DEVELOPMENT HEARING OFFICER

PR-2020-004747

SD-2024-00081 – PRELIMINARY/FINAL PLAT

Project Name: Albuquerque Data Center- Daytona Rd. NW between 94th and 90th St

PROJECT NO.: 193806697  
DWN BY: HKK    CHKD BY: JRA    APPD BY: CMR  
ISSUE DATE: 08/01/2024  
ISSUE NO.: 5  
SHEET TITLE: SITE PLAN  
SHEET NO.: C-101

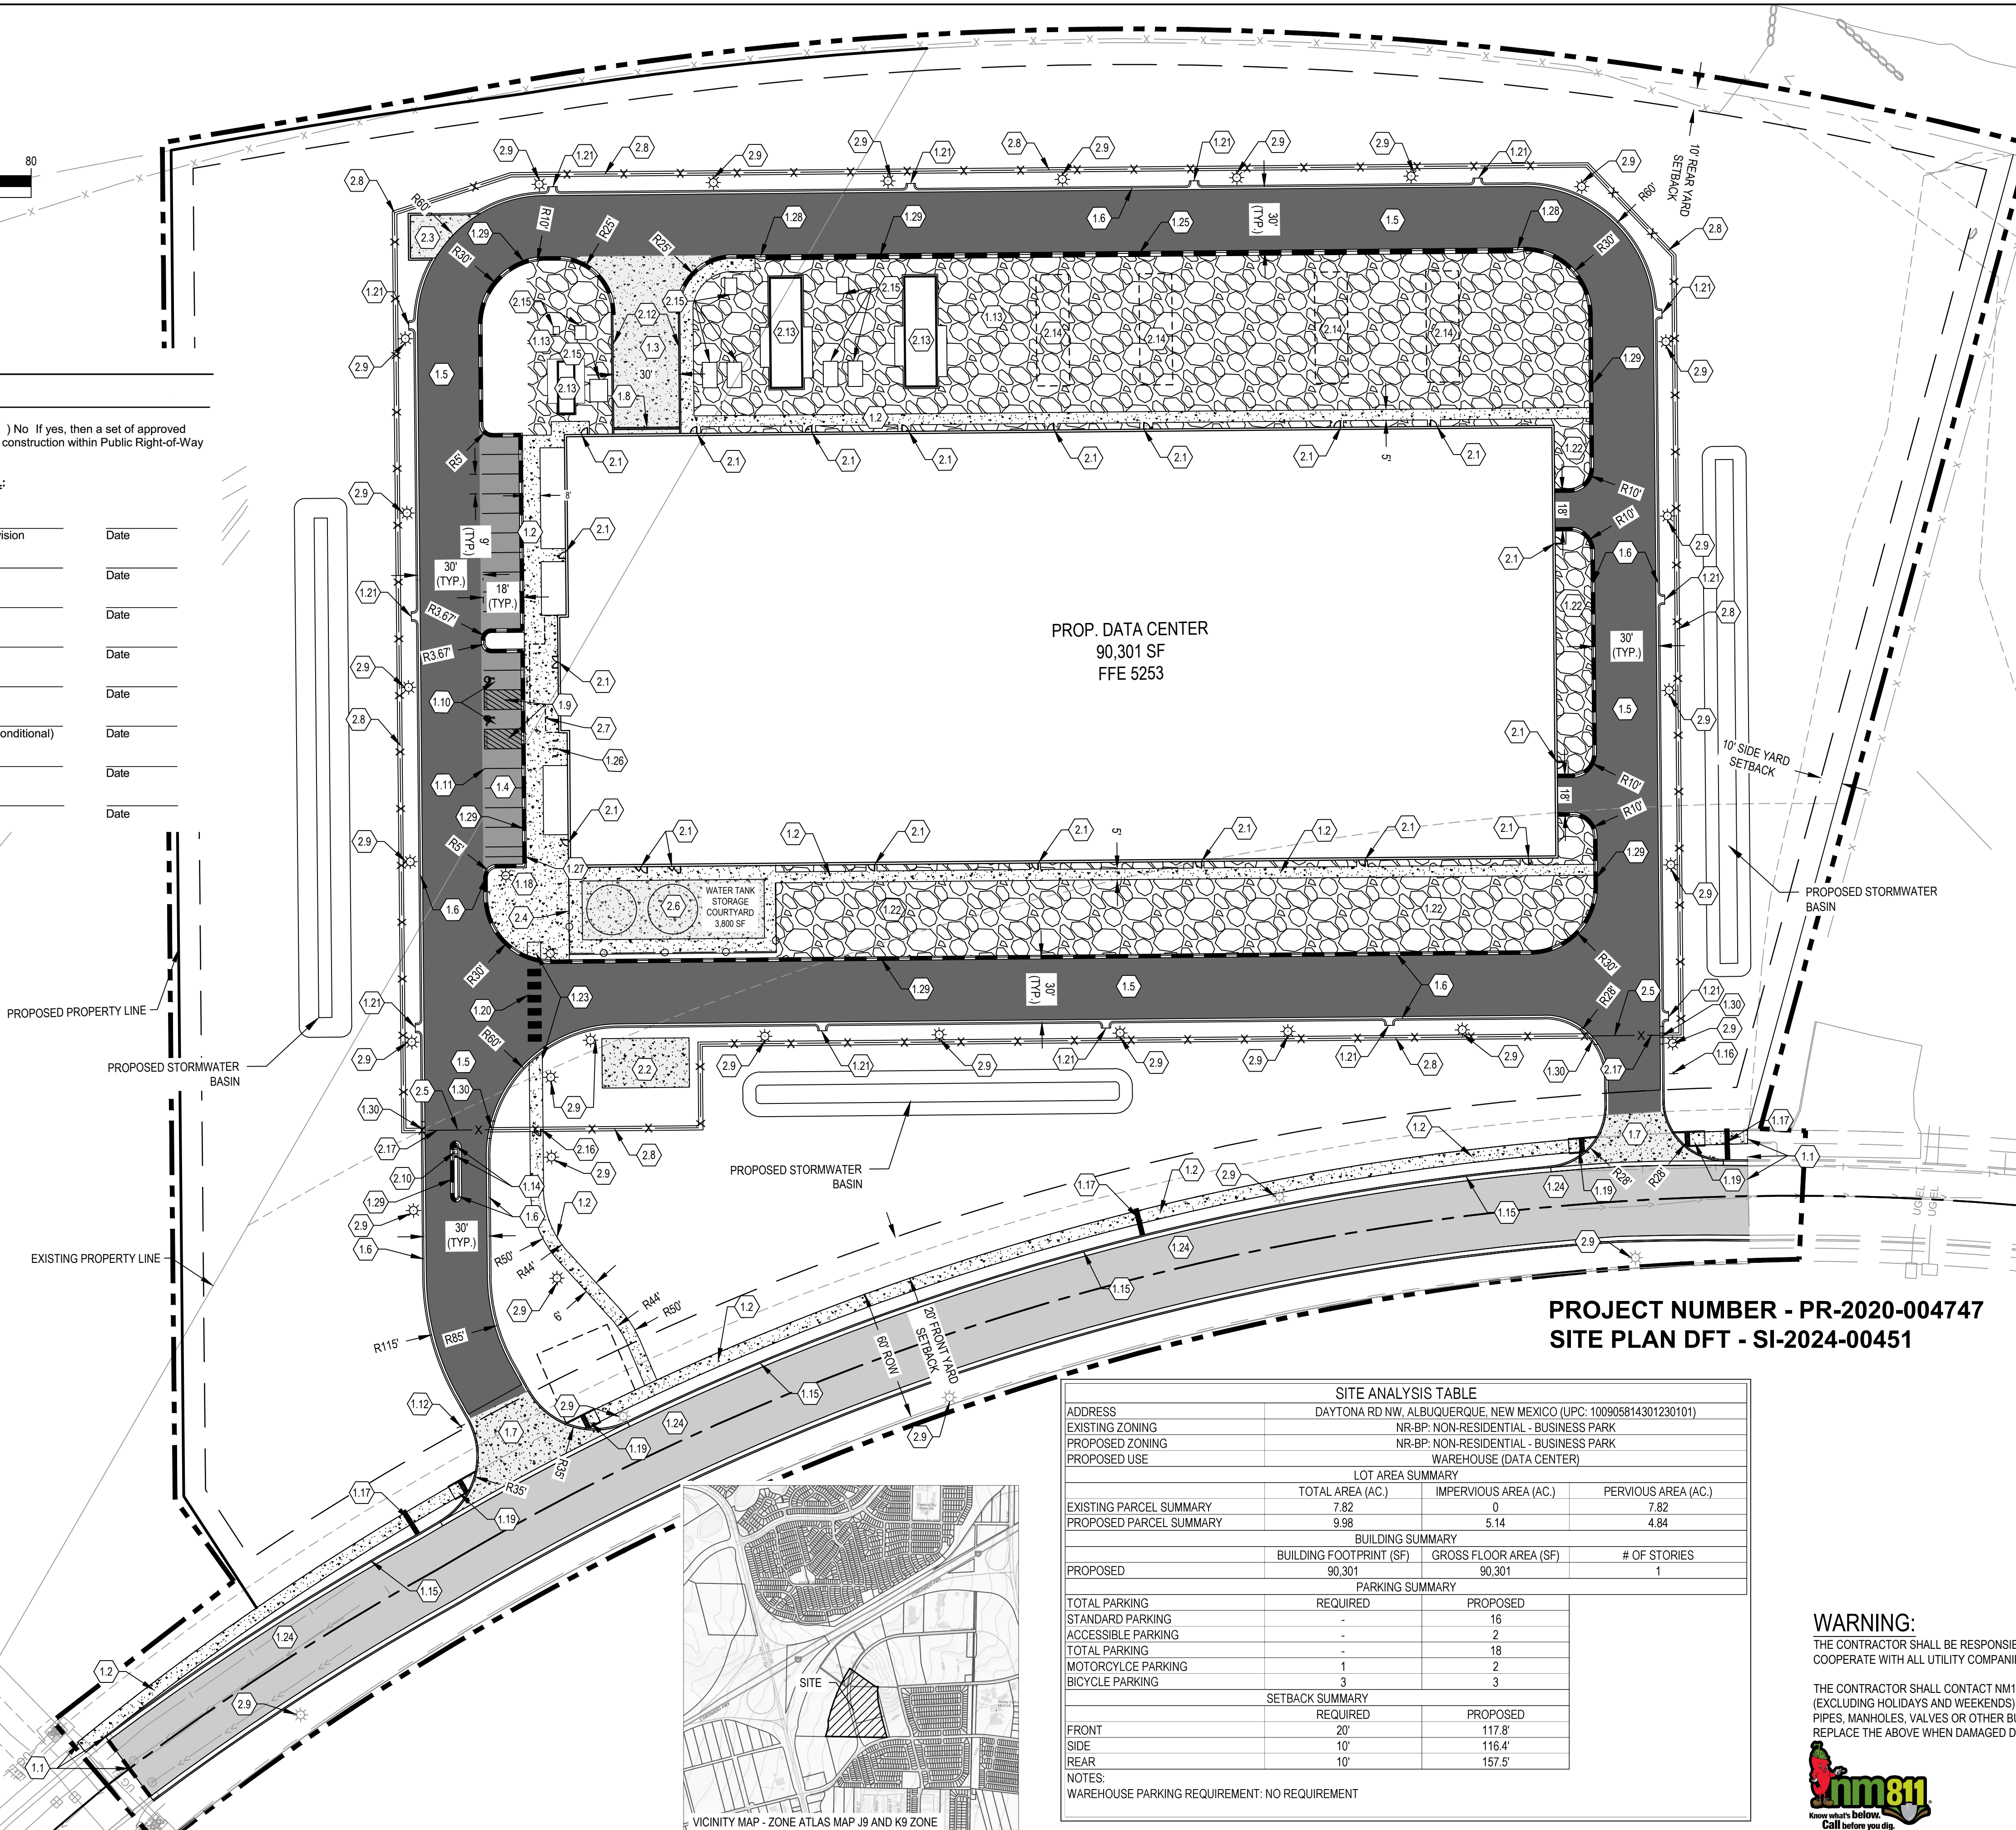
3. Please clarify types of use proposed for calculation of parking. Site Plan and application indicate Office use and data center. Justification letter shows it as Warehouse. Please determine correct use as defined by the IDO.

4. Parking must meet all requirements of IDO 5-5, Table 5-5-1. Must show amount of floor area dedicated to each respective use, parking requirements for that use, and total required parking calculations based on areas of use.

5. Walls and fences must meet requirements of IDO 5-7, Walls and Fences, as per Table 5-7-1 and related sections for materials and height allowed. In the NR-BP zone, wall heights may be determined and called out in the Master Development Plan. If not called out in the Master Development Plan, then the NR-BP zone is limited to 8 ft in side/rear yards and 6 ft in front or street side, if set back 5 ft from property line and view fencing above 3 feet, as per IDO 5-7(D)(3). Anything higher will require a Variance.

6. Need to provide Landscaping plan meeting requirements of IDO 5-6, with calculations shown for percent of net lot area, percent of coverage, number of street trees, and all other applicable requirements.

7. Lighting must meet requirements of IDO 5-8 Outdoor and Site Lighting.
8. Site plan should show how Building Design is meeting applicable requirements of IDO 5-11, Building Design.
